Gilbert C. LaForce, P.E.
El Paso County
Planning and Community Development
2880 International Circle, Suite 110
Colorado Springs, CO 80910

RE: Cloverleaf TIS Response to Comments

Kellar Engineering (KE) comment responses in **blue** font.

Figure 3: Recent Peak Hour Traffic

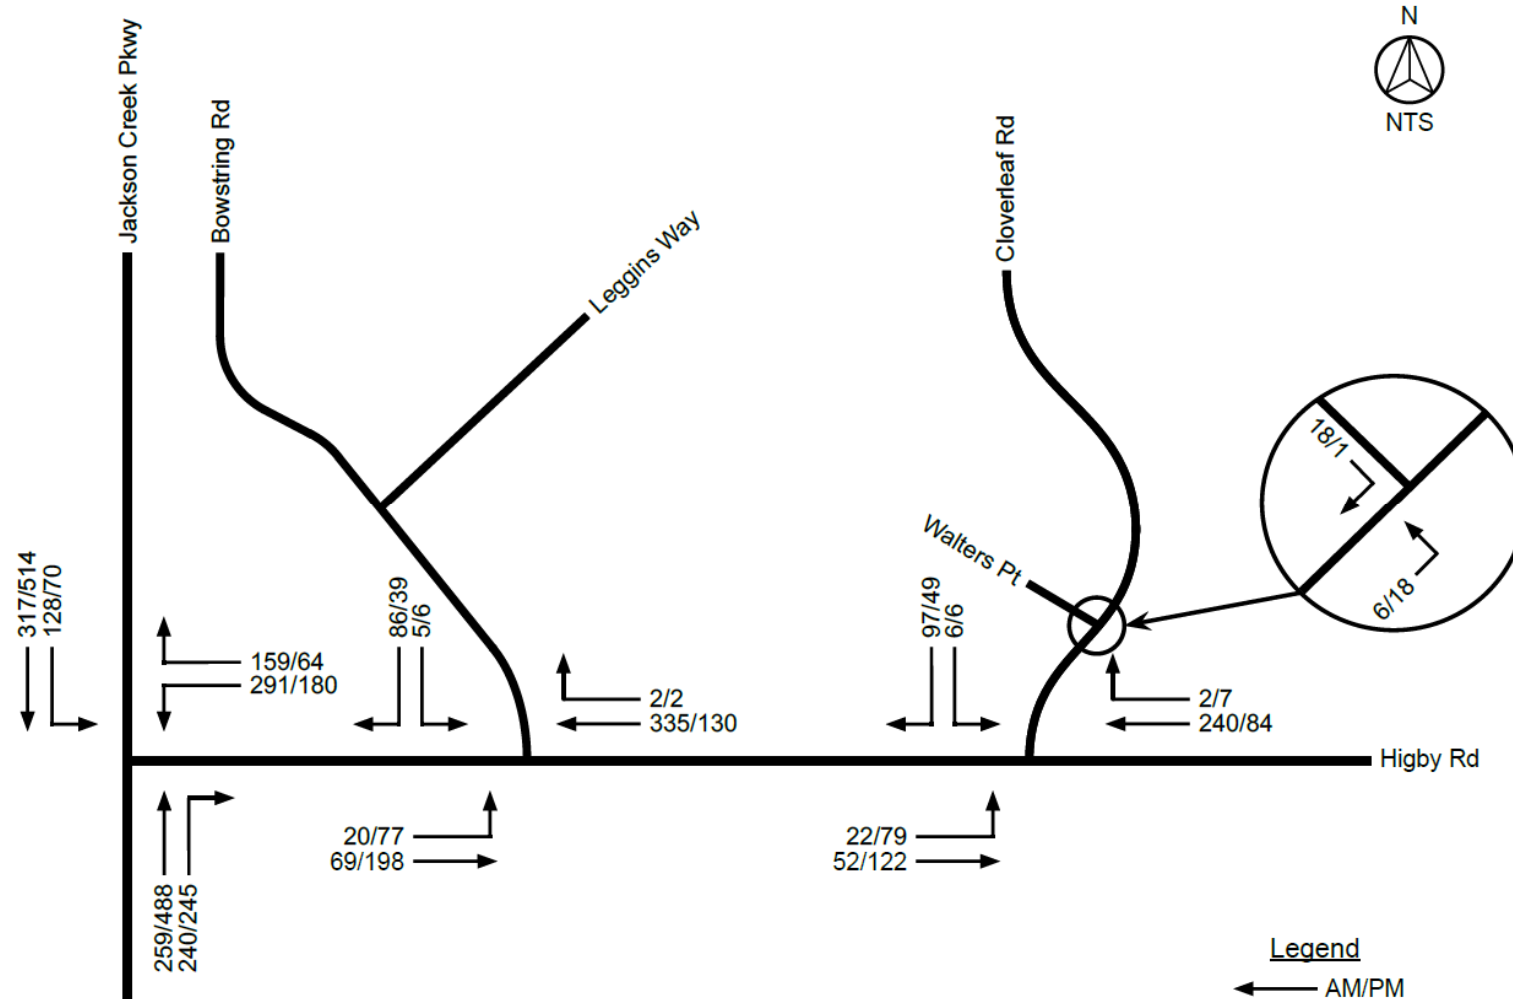
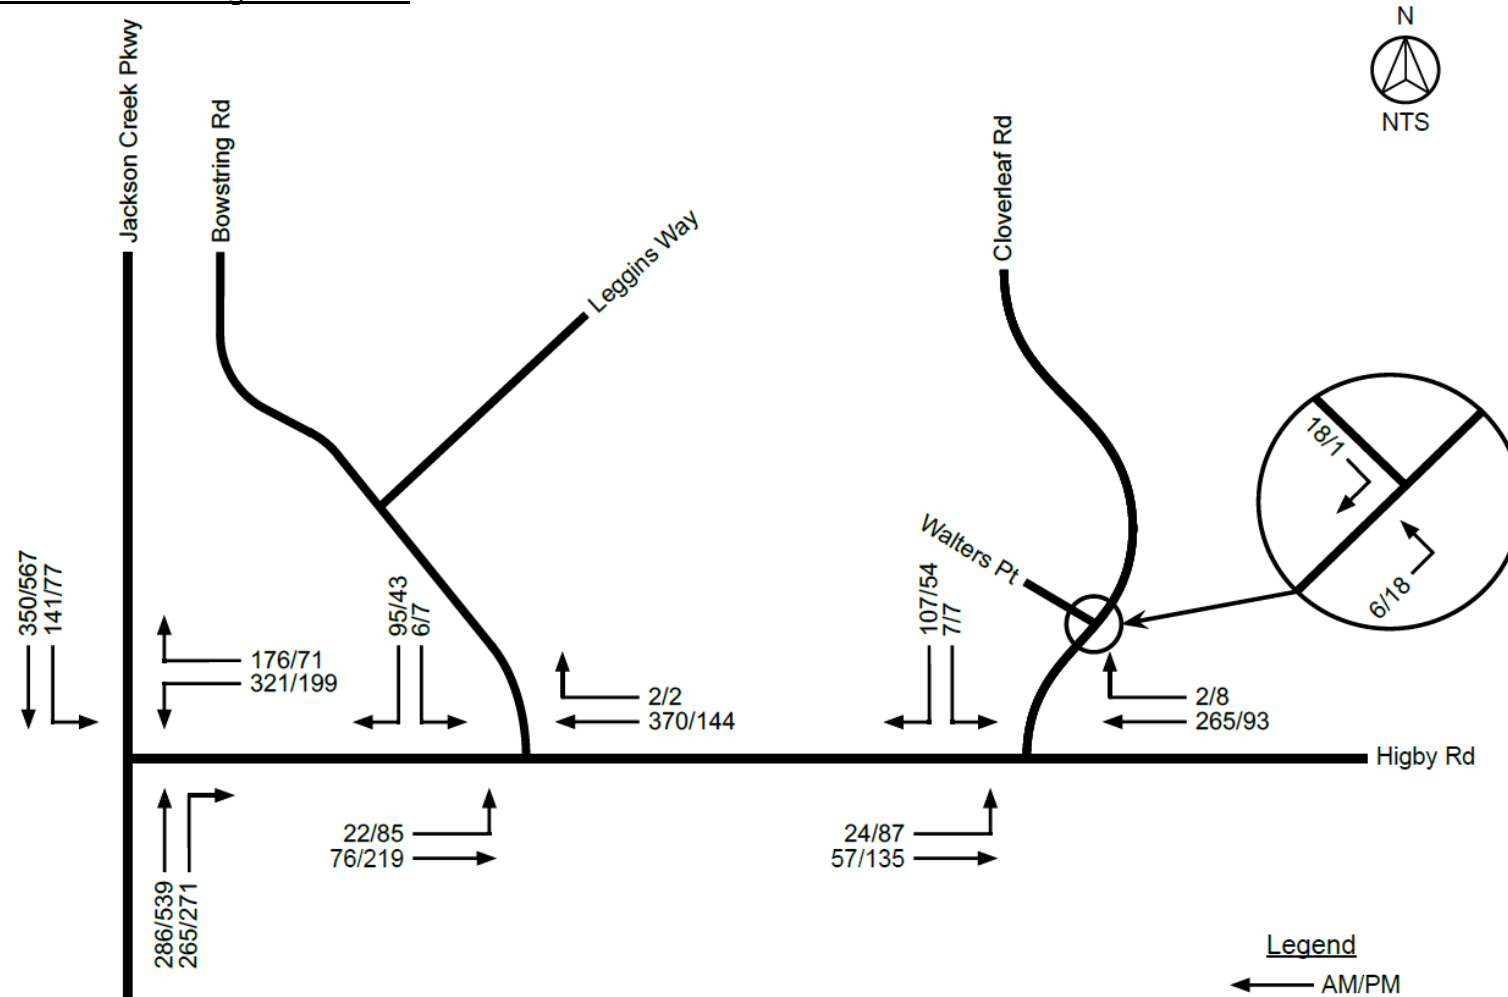
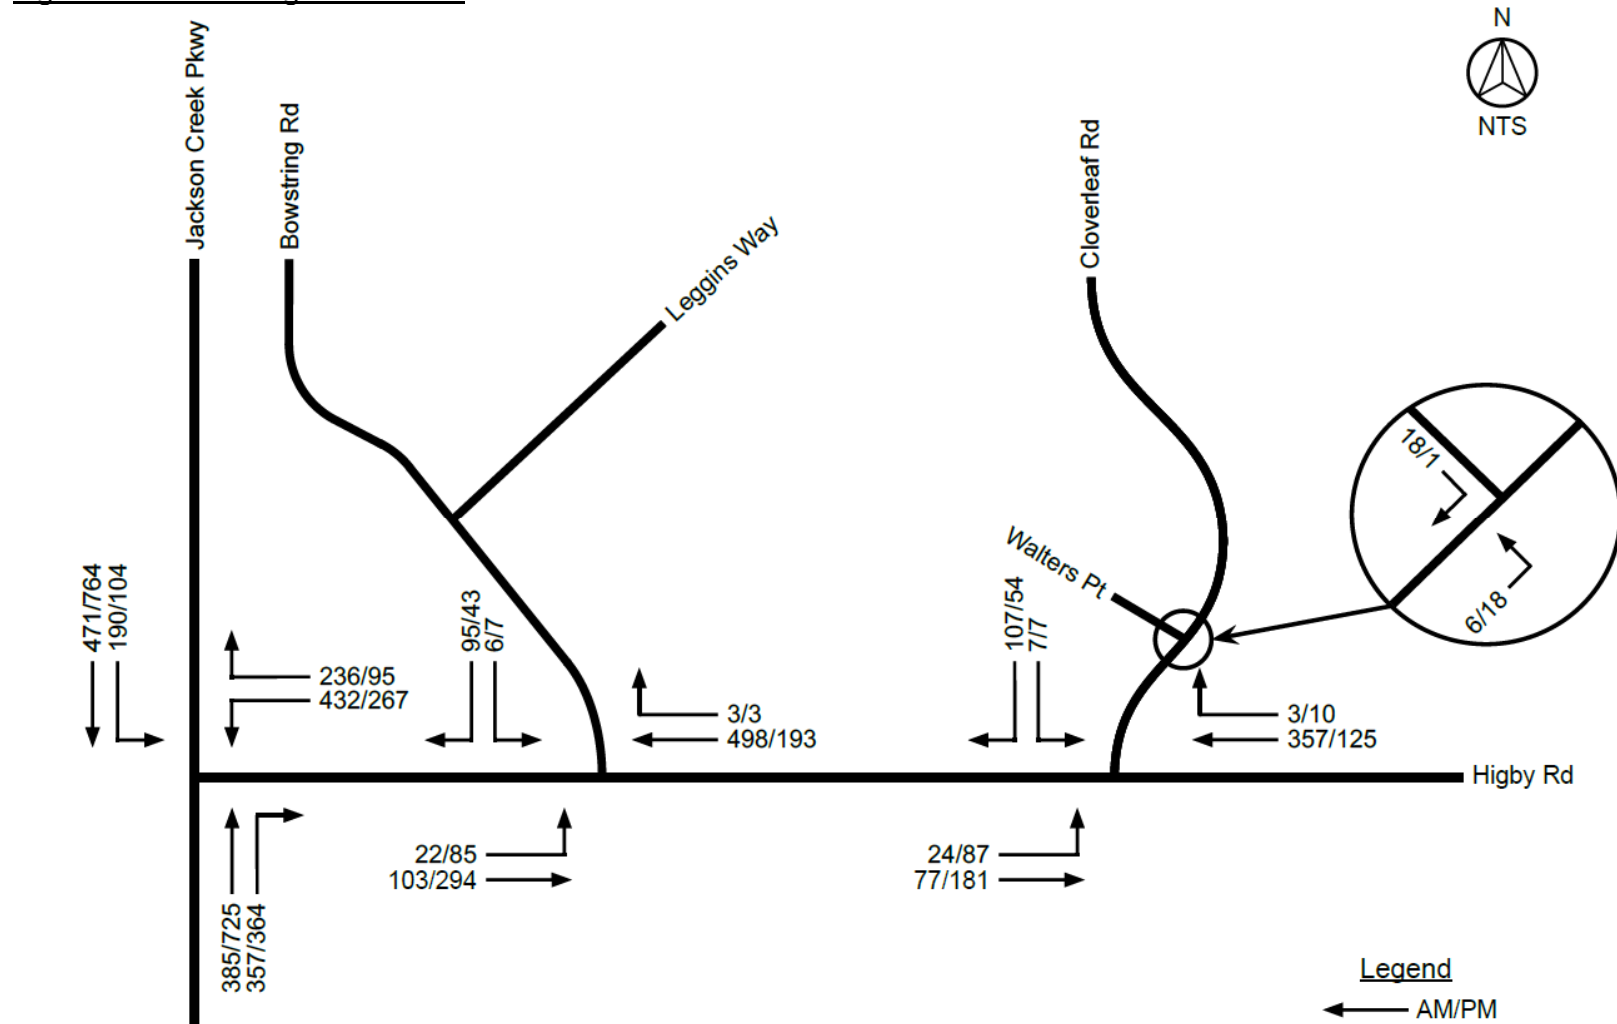
9. Comment. Add Walters Point in the TIS analysis. The applicant submitted a deviation request classifying Walters Point as Urban Local Low Volume with approximately 450 ADT with no supporting traffic analysis for the value stated.

Response. See Section 4.1 in the updated TIS.

Figure 6: Trip Distribution

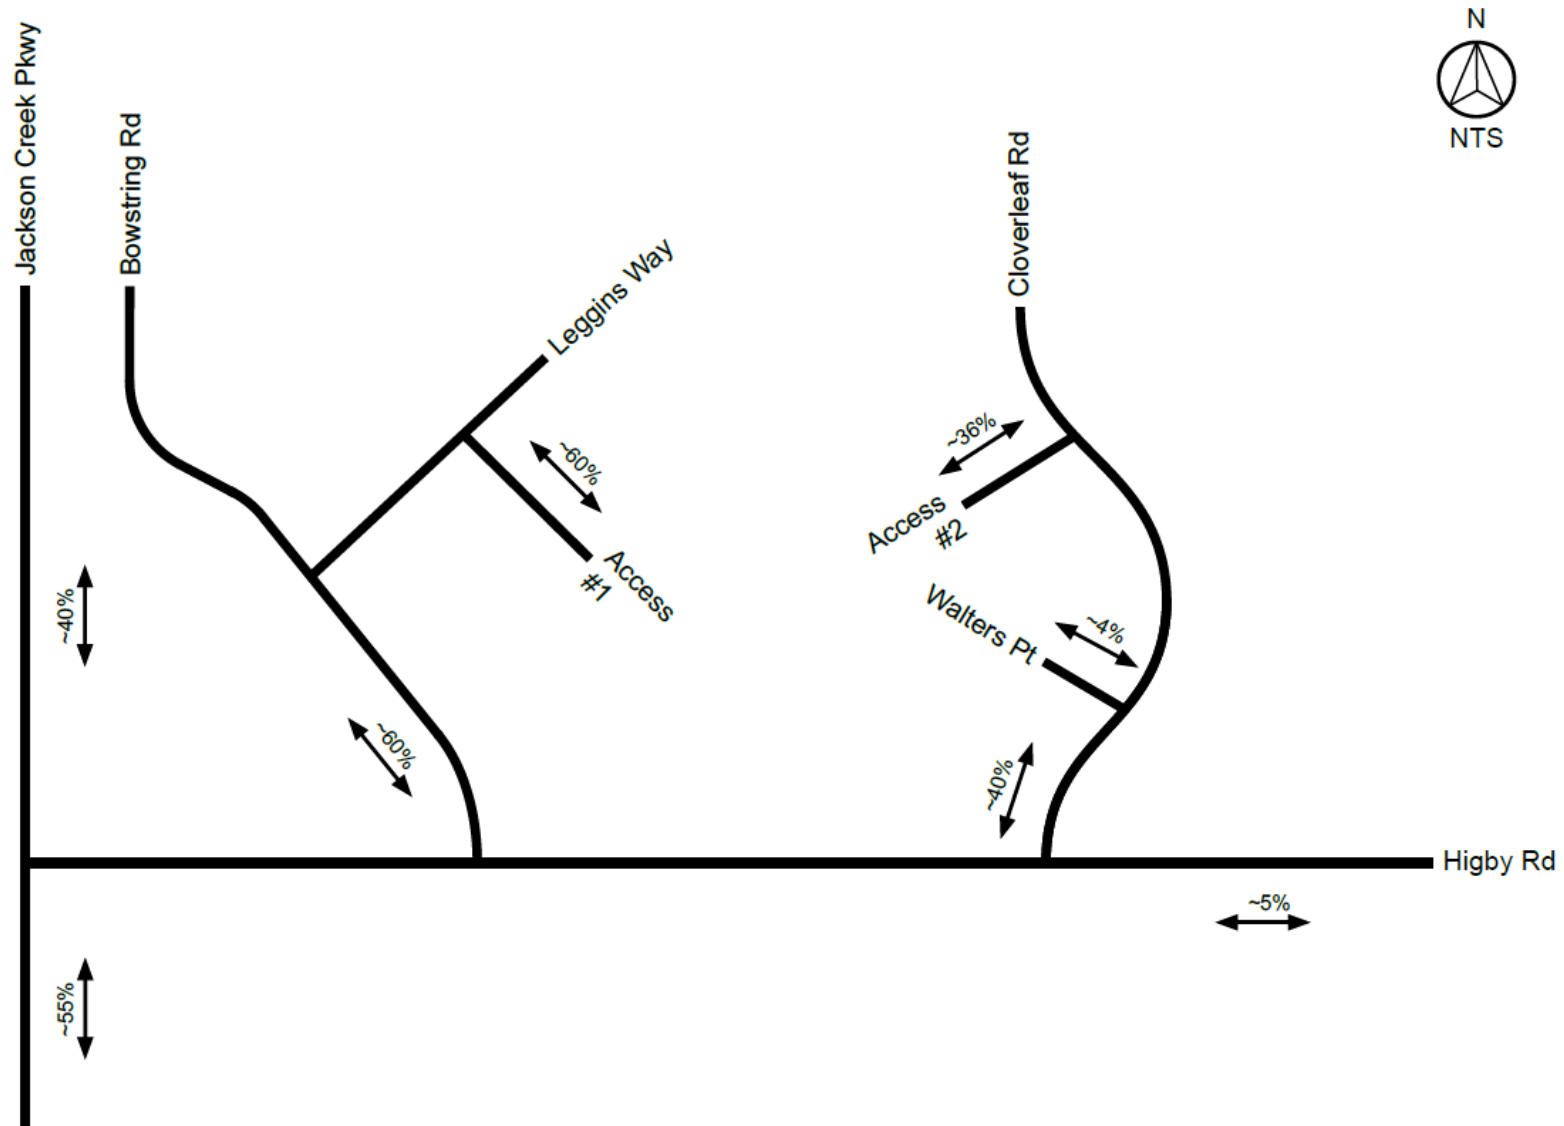
2. Comment. Provide the percent distribution going to Access 1 and Access 2.

Response. Added to Figure 6 in the updated TIS.

Figure 8: 2025 Short Range Total Traffic

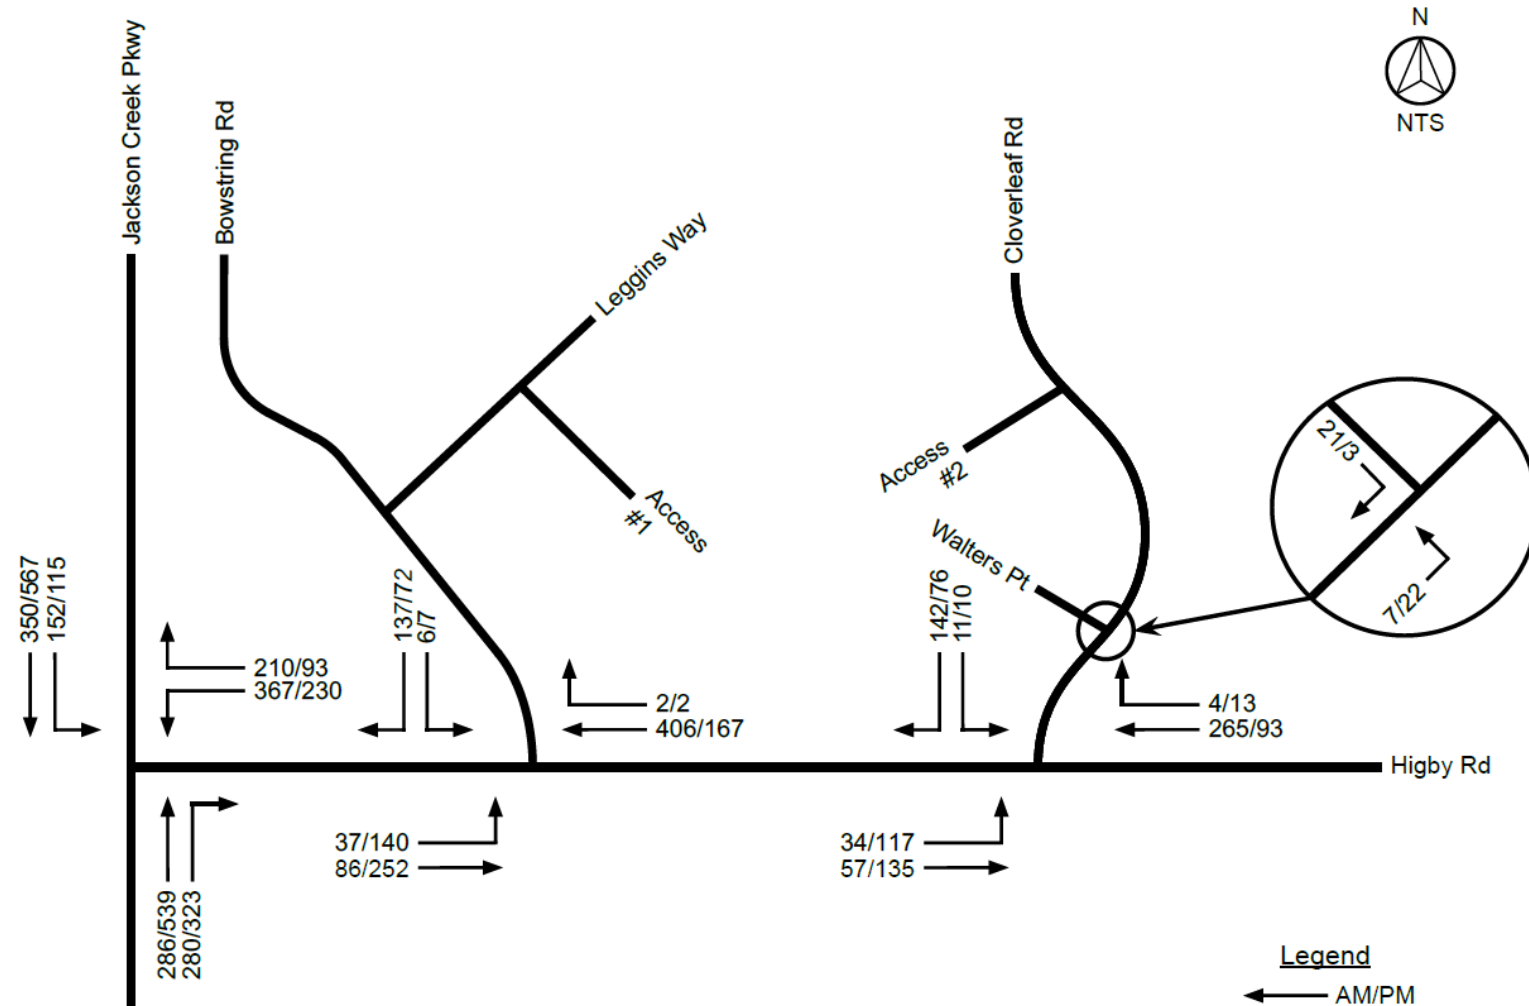
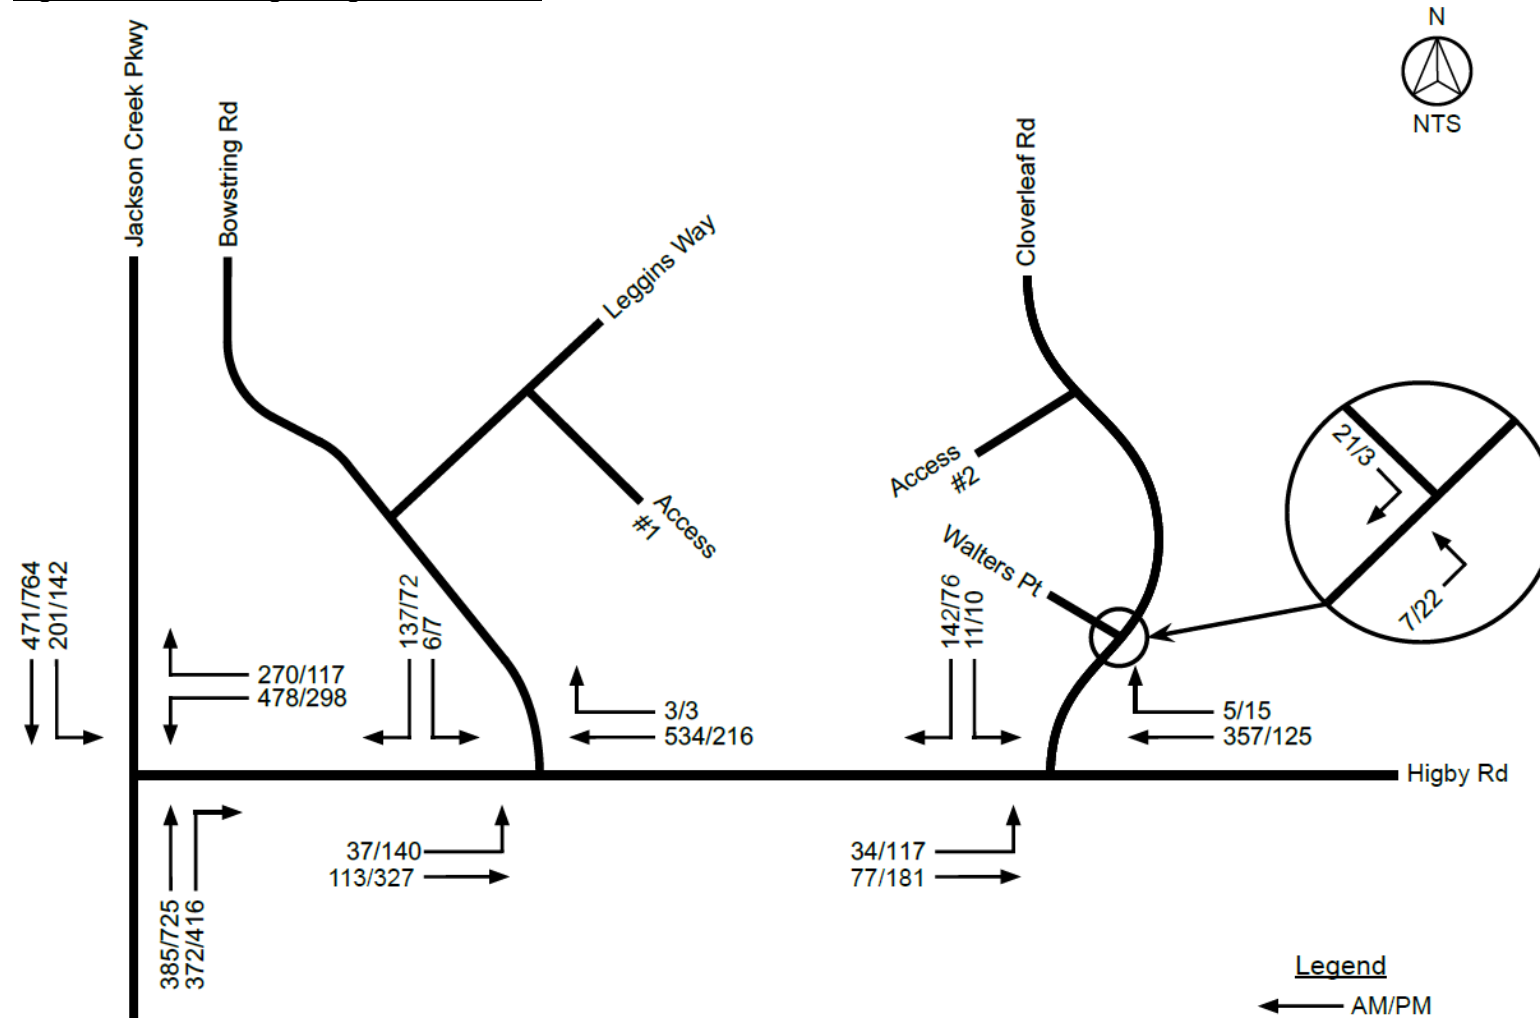
5. Comment. Provide the ADT on Bowstring, Leggins & Cloverleaf in the 2025 and 2040 total traffic. Update the narrative to discuss whether or not the project results in the existing roads exceeding the design capacity (ECM Table 2-5) for rural local roads. Provide mitigation improvement recommendations.

8. Comment. Add Walters Point and include the estimated ADT.

Response. Added to Section 4.1 in the updated TIS.

Response. See Section 4.1 in the updated TIS.
